# CITY OF ALBUQUERQUE

March 3, 2015

RE: **Chick-fil-A**  
**210 Eubank Blvd SE**  
**Grading and Drainage Plan**  
**Engineers Stamp Date None (L21D045B)**

PS-1.0

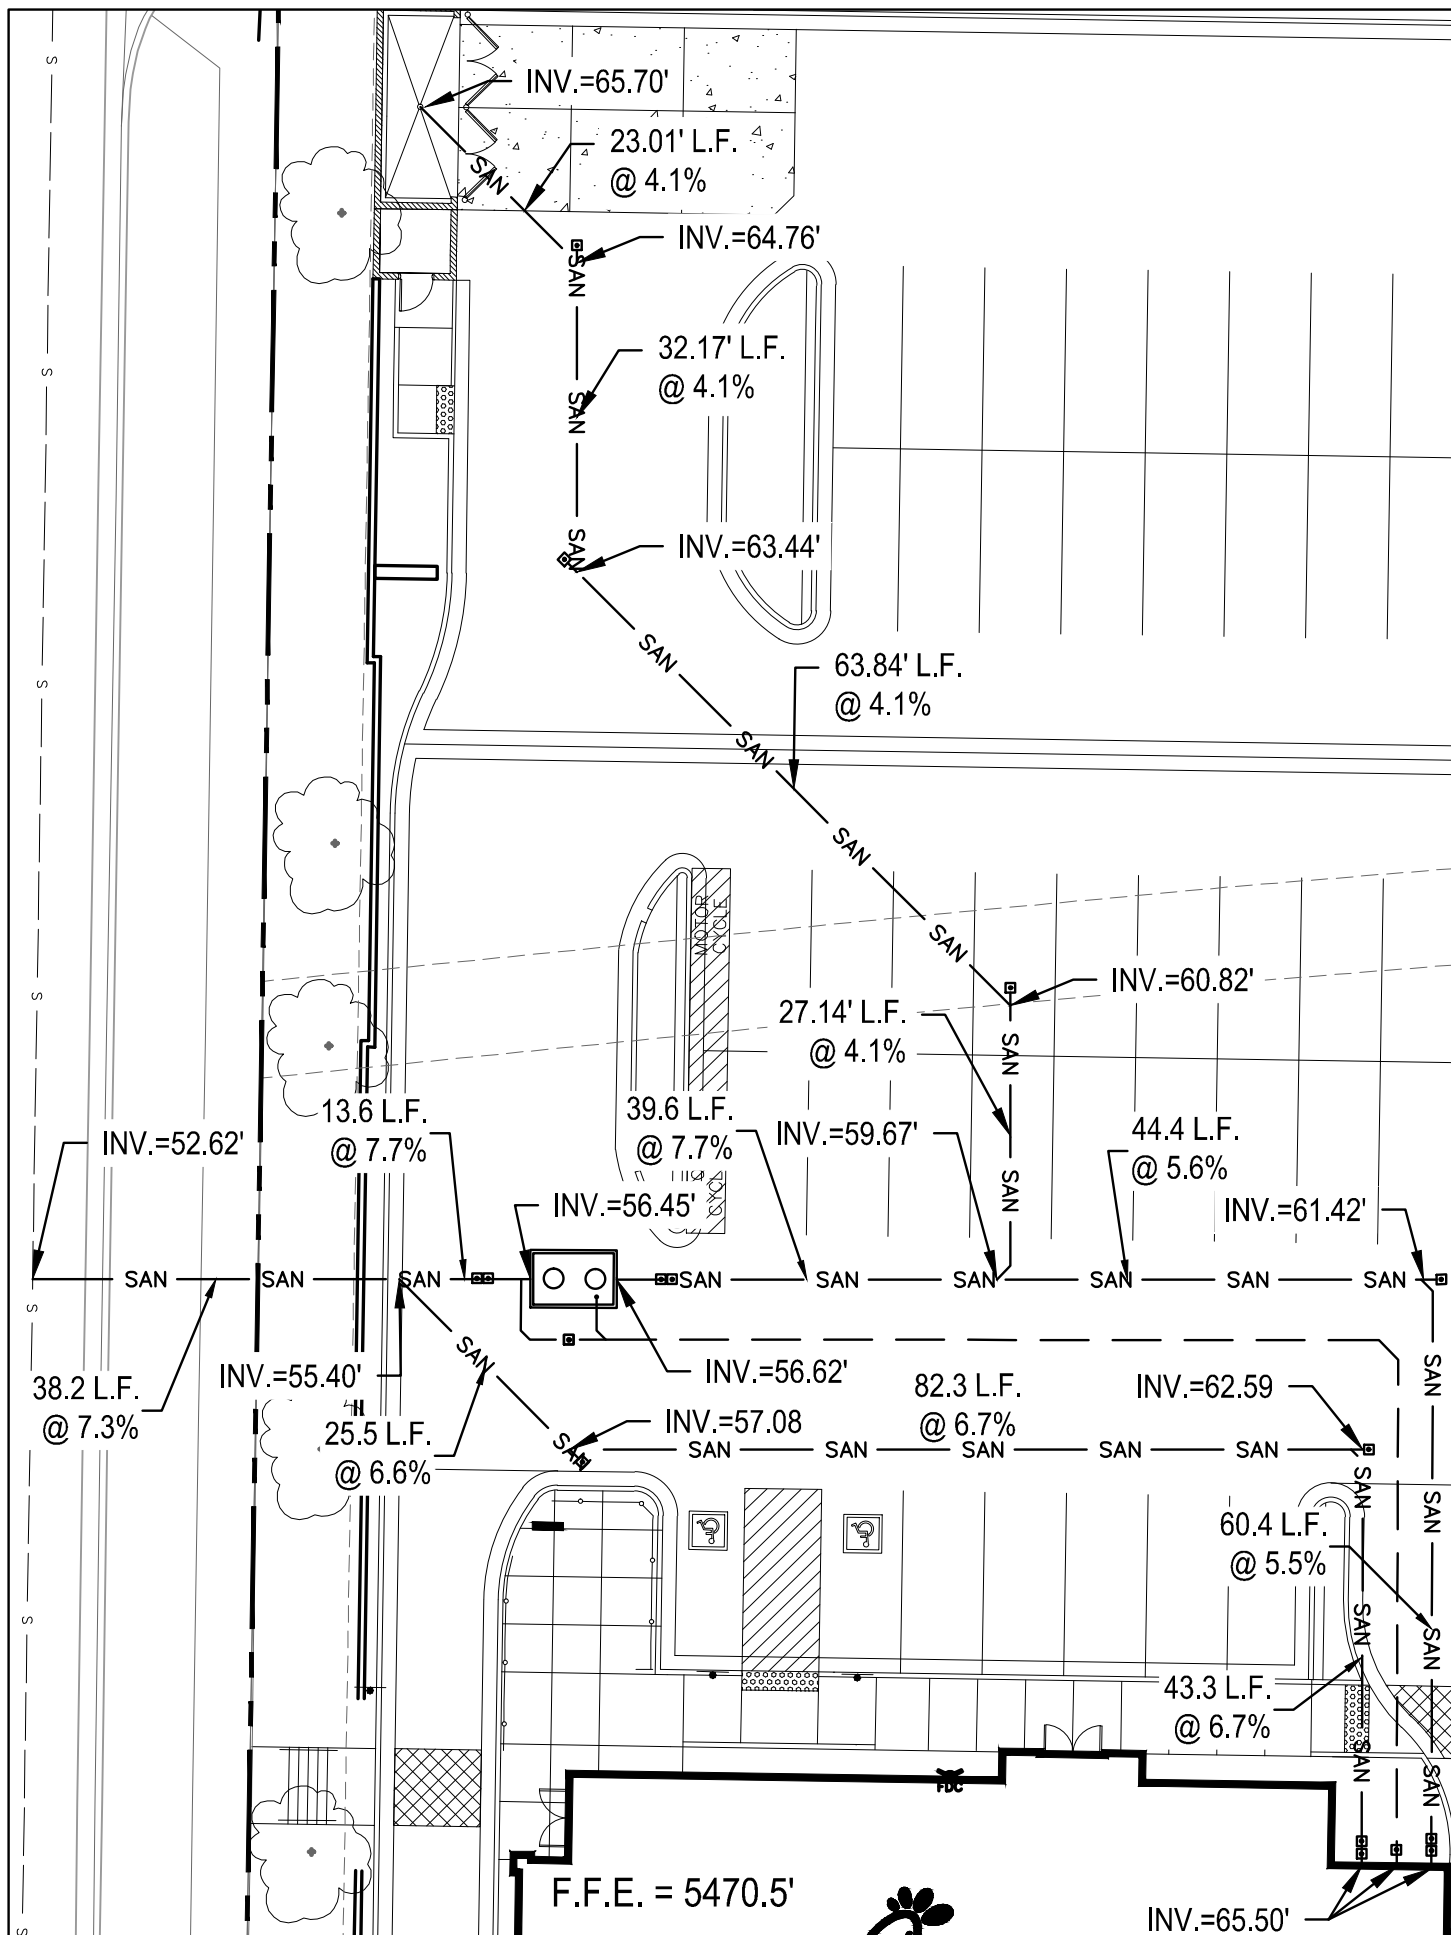
- Mention of the first flush per EPA standards is required and placed on the plans. The amount required is .34" times the impervious area. Place the inlets in the landscape islands/areas for first flush requirements.
- The dumpster area must contain a drain connected to the SAS, with a grease trap.
- Provide Engineer stamp, date and signature.
